**WEST SUSSEX COUNTY COUNCIL
PLANNING SERVICES CONSULTATION**

SUBJECT: P/1/18/DOC - Application for approval of details reserved by conditions imposed under planning permission P/125/14/PL relating to condition No. 10 (Refuse & recycling bins), condition No.14 (Visitor Parking Spaces), condition No.15 (Surface water onto Highway), condition No. 16 (Street Lighting), condition No. 18 (Cycle Parking), condition No. 21 (Landscaping), condition No. 22 (Screen Walls & Fences) & condition No.26 (External Lighting), condition 31 (Dog Walking)

LOCATION: 251 Pagham Road and Land R/O, Pagham, PO21 3QB

This is the WSCC Highway Authority response to the planning application for discharge of conditions 10, 14, 15, 16, 18, 21, 22, 26 and 31 (full details given above).

drawing title	Landscape General Arrangement (East)				
drawing no.	1896-TF-00-00-DR-L-1002				P03
scale	1:250 @ A1	date	28.09.17	drawn by	AC
				checked by	AC

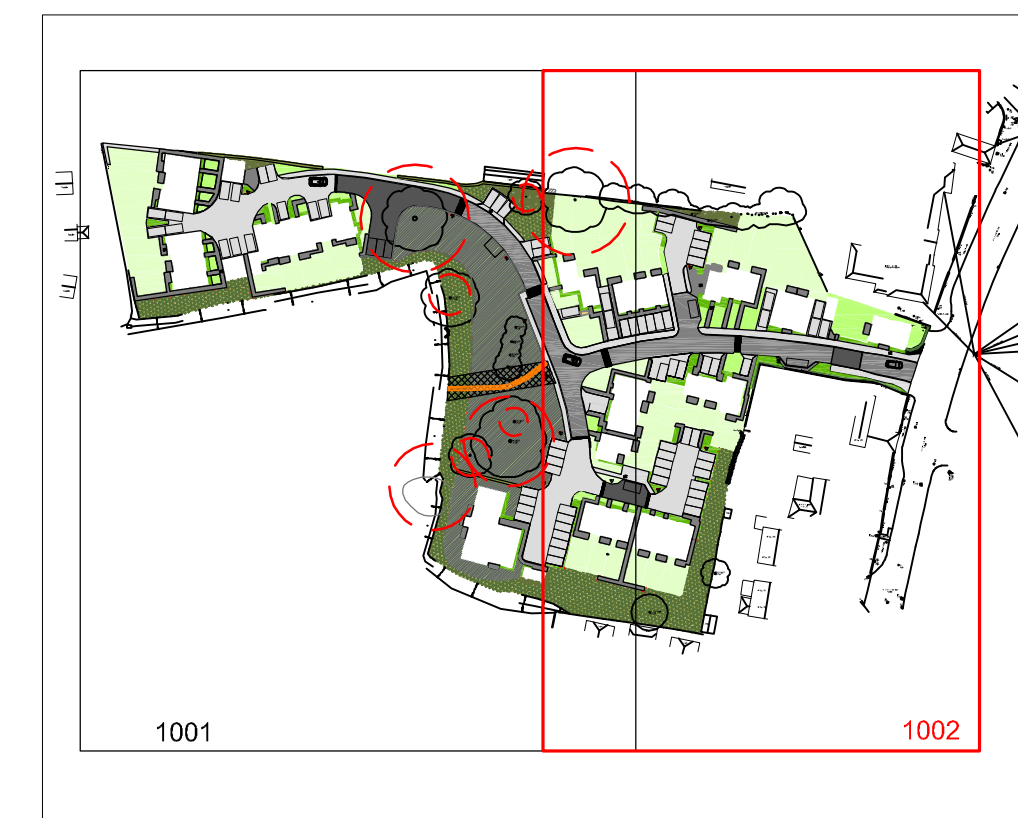
- 6. Condition 21 (landscaping)** – All planting appears to be behind extent of adoptable highway – therefore, no highway objection.
- 7. Condition 22 (screen walls and fences)** – For LPA.
